CITY OF ALBUQUERQUE

May 1, 2013

**Re: West Ridge MH Park
Grading and Drainage Plan
Engineer's Stamp date 04-15-2013 (K-09/D006)**

WEST RIDGE MOBILE HOME PARK	DRAWN BY DY/BJF
	GRADING AND DRAINAGE PLAN	DATE 12-07-10
	TIERRA WEST, LLC 5571 MIDWAY PARK PLACE NE ALBUQUERQUE, NM 87109 (505)858-3100 tierrawestllc.com	2731-GRE
		SHEET # C3
		JOB # 27031

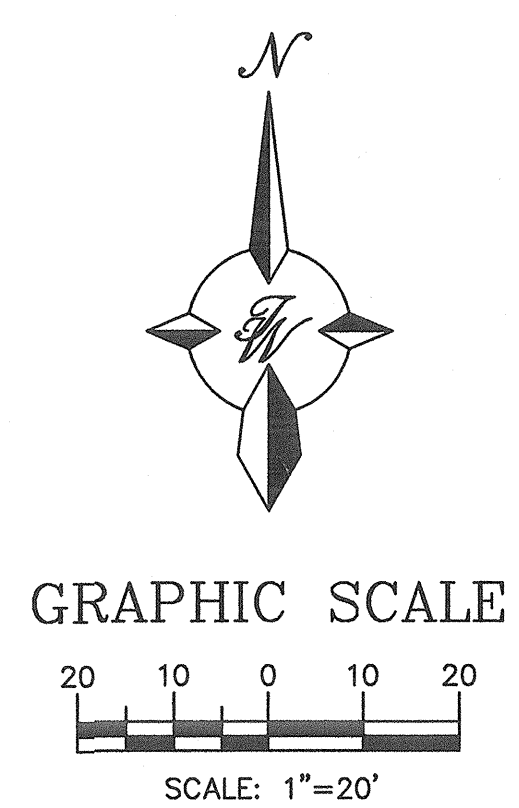
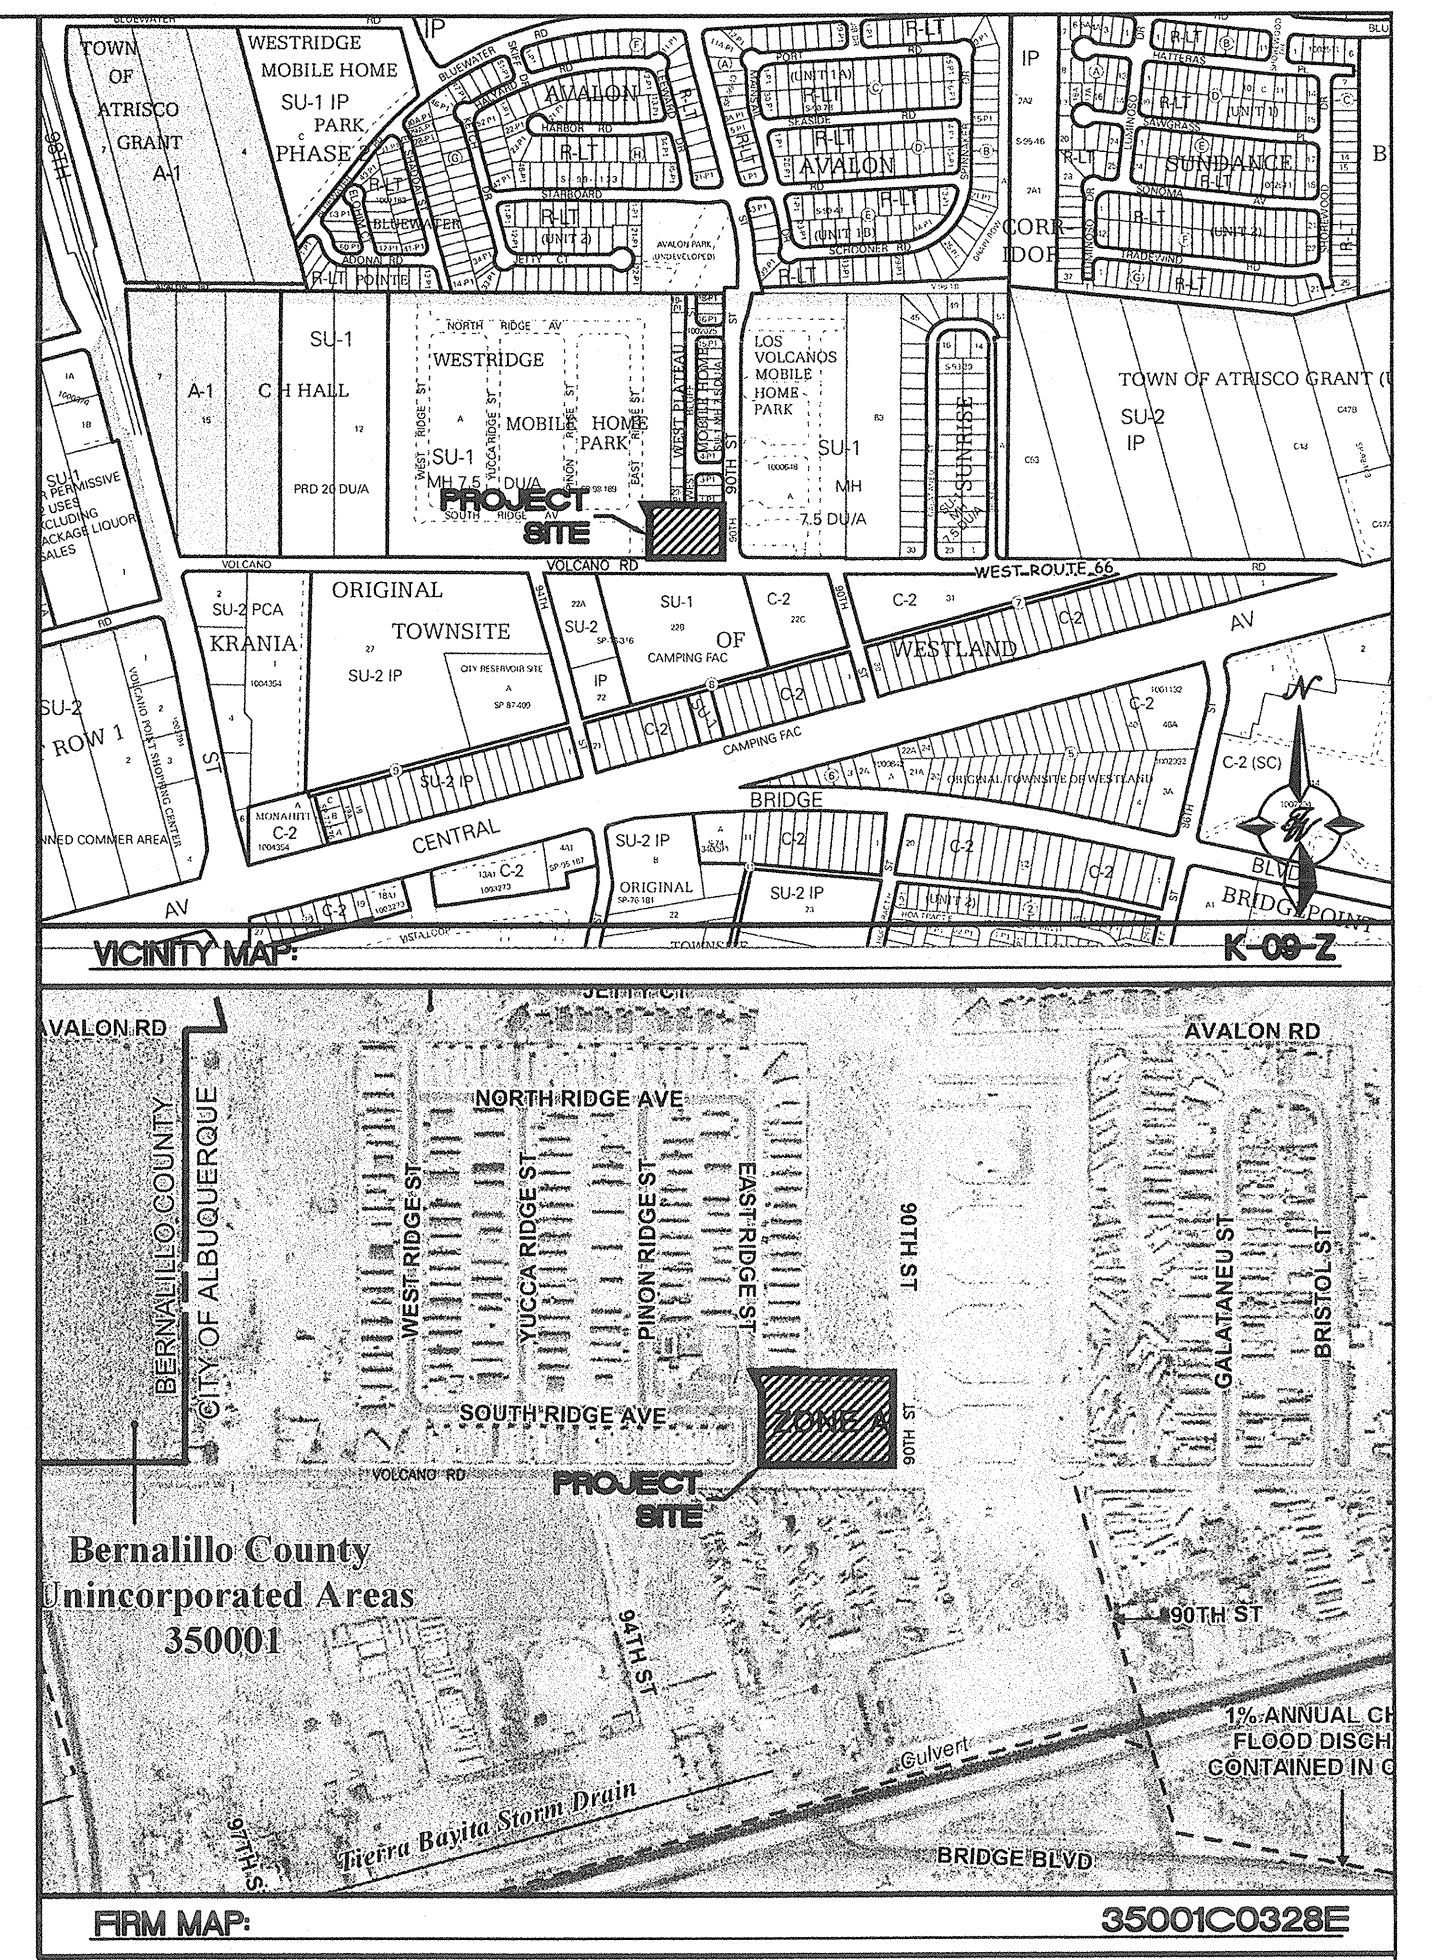
Based upon the information provided in your submittal received 04-22-13, the above referenced plan can not be approved for Grading Permit until the following comments are addressed.

- An emergency overflow needs to be added.
- Label existing contours.
